Our Case Number: ABP-317560-23

Ár dTag | Our Ref.
TII23-123905

Re. **Strategic Infrastructure Development – Proposed windfarm development including 13 no. wind turbines in Bunnyconnellan, Co. Mayo & hydrogen plant in Castleconnor, Co. Sligo**

ABP Case ref. PA16.317560

Figure NTS-5: Proposed Turbine Delivery Haul Routes

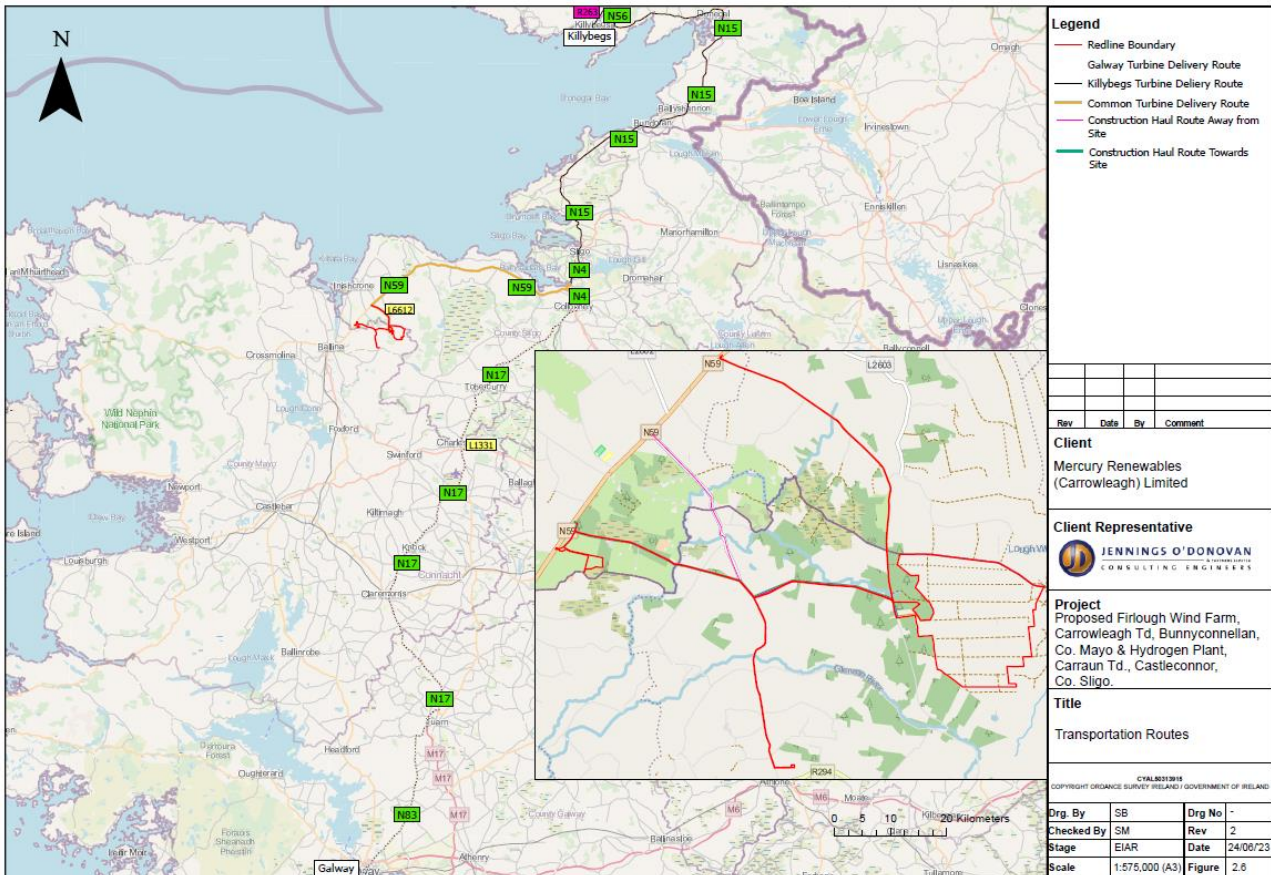
In the interests of clarification, TII's initial submission advised that it was critical that a full assessment of all structures on the national road network along the haul route should be undertaken, not just along the construction haul route as referenced in the applicants response but in relation to the entire turbine component haul route to site.

It remains TII's position that a full assessment of all structures on the national road network along the turbine component haul route to site should be undertaken. In addition, as advised above, the applicant is aware that any operator who wants to transport a vehicle or load whose weight falls outside the limits allowed by the Road Traffic (Construction Equipment & Use of Vehicles) Regulations 2003, SI 5 of 2003, must obtain a permit for its movement from each Local Authority through whose jurisdiction the vehicle shall travel.
